Planning Application Reference: AL/2/21/DOC

Proposal: Approval of details reserved by condition imposed under ref AL/51/20/PL relating to Condition Nos 3 - materials & finishes, 5 - Energy Statement, 7 - car parking and 14 - external lighting

Address: Tyrone House Norton Lane Norton PO20 3NH

FIGURE 2 - PROPOSED EXTERNAL LIGHTING

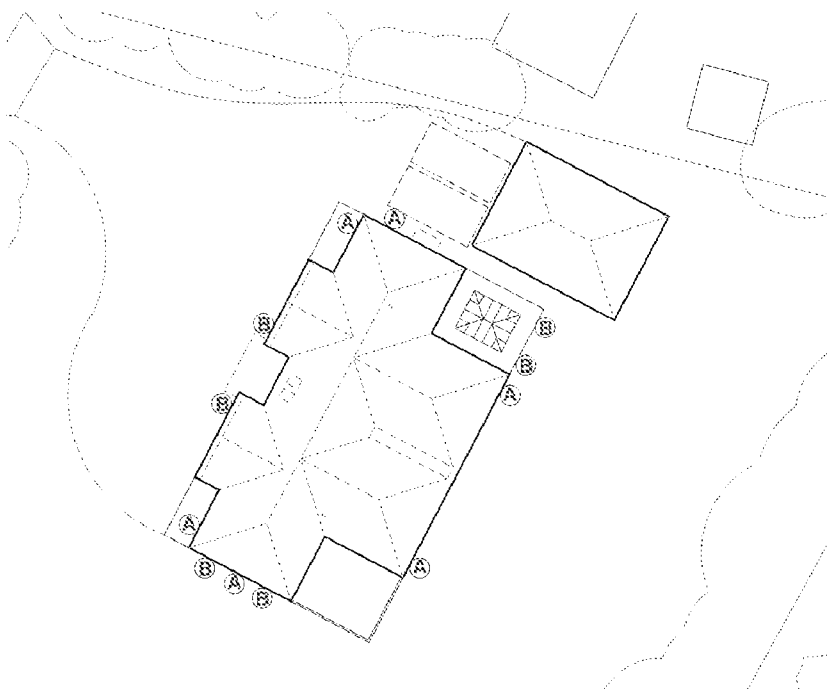
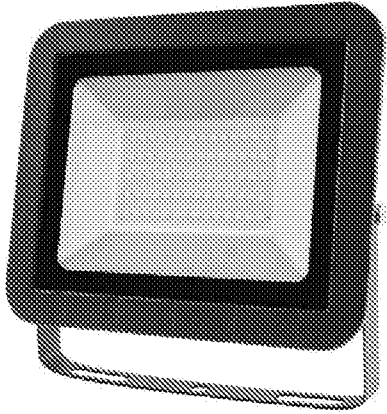
There is insufficient information to determine whether the proposed external lighting may potentially cause a light nuisance to neighbours. I note the proposed location of spot lights 'A', however a lux diagram showing the spot light orientation and extent of light spill is required to assess for potential light nuisance. I therefore recommend that the applicant be required to submit a lux diagram illustrating the orientation and extent of light spill from the proposed spot lights.

I therefore do not recommend discharge of condition 14 (external lighting) based on the submitted information.

I have had a look at these new light fittings and they are much better, I am happy for the condition to be discharged now.

We have revisited the previously suggested spotlight fitting (referenced A in Figure 2) and would like the attached fitting to be considered instead. Lux diagrams for this fitting included.
